KIRKLEES METROPOLITAN COUNCIL INVESTMENT & REGENERATION SERVICE

DELEGATED DECISION TO DETERMINE PLANNING APPLICATIONS

Reference No:	2022/62/91604/W
Site Address:	66, Blacker Road, Birkby, Huddersfield, HD1 5HS
Description:	Alterations to existing dwelling to form 3 flats with rear dormer and erection of bike shed (within a Conservation Area)
Recommending Officer:	Katie Chew

DECISION - Refusal

PROPOSED 2ND FLOOR PLAN
(FLAT 3)

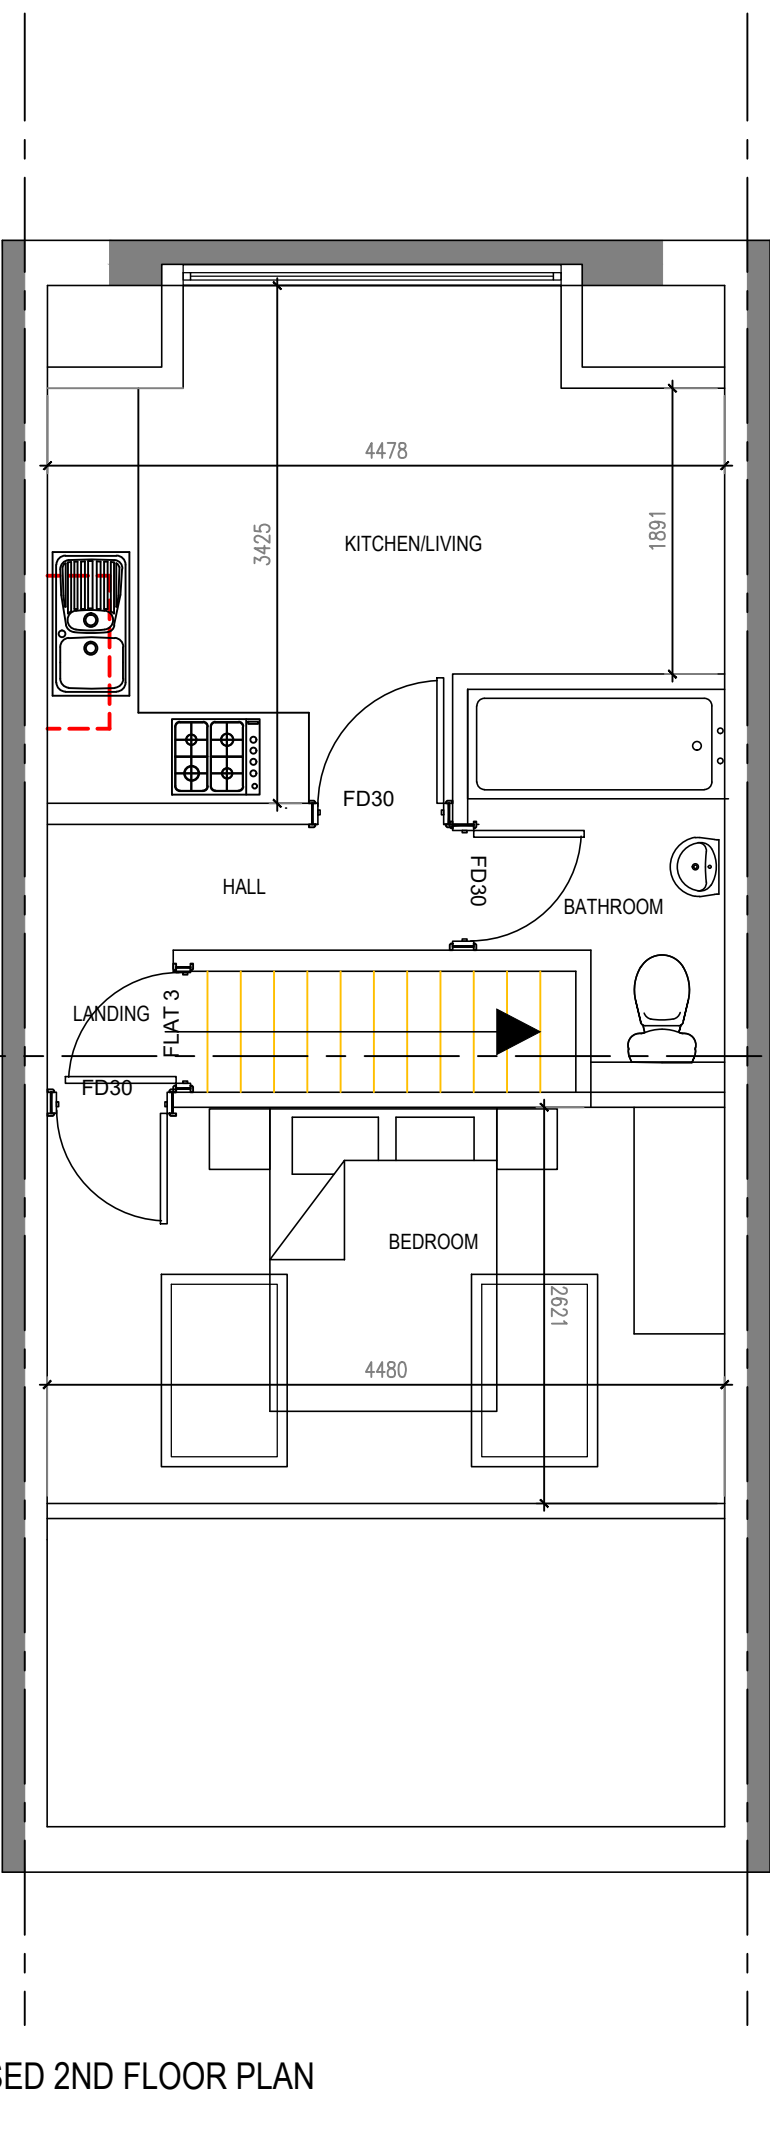
Flat 1 measures 40sqm, Flat 2 measures 46sqm and Flat 3 measures 35sqm. However, it is also noted that flat 3 is located within the roof space of the existing dwelling and without any details showing the head heights of this space officers cannot assess the overall size of this space. Although it is likely that the useable internal floor space would be less than 35sqm. Given the above recommendations, it is considered that all 3 units would fall short of this part of the national standards should double bedrooms be provided. Flats 1 & 2 would be acceptable should just 1 person occupy each flat. However, flat 3 would not be suitable in this instance and would not provide an adequate living standard for any future occupier.

With regards to Flat 1 the double bedroom has an approximate floor area of 10.68sqm and a width of 2.39m. Thus, supporting the view that this bedroom should be occupied by one single person. The bedroom at Flat 2 has an approximate floor area of 11.9sqm and a width (at its smallest) of 3.3m. The bedroom at Flat 3 has an approximate floor area (not taking into account floorspace which has a head height of less than 1.5m) of 12sqm and a width of 4.6m.

In conclusion, taking the above into account it is considered that Flats 1 & 2 would be acceptable should they be occupied by 1 single person. Flat 3 however would fall below the recommended guidelines for gross internal floorspace, and therefore would result in a poor standard of residential amenity for any future occupier. As such the proposals are not considered to comply with Policy LP24 of the Kirklees Local Plan, Principle 16 of the Council's Housebuilders Design Guide SPD and Chapter 12 of the National Planning Policy Framework.

1. The proposed development, by reason of the limited amount of useable internal floorspace provided within Flat 3, would provide a poor standard of amenity to future occupiers. Therefore, the development would be contrary to the aims of National Planning Policy Framework paragraph 130(f) of the National Planning Policy Framework, Principle 16 of the Housebuilders Design Guide SPD and Policy LP24(b) of the Kirklees Local Plan.
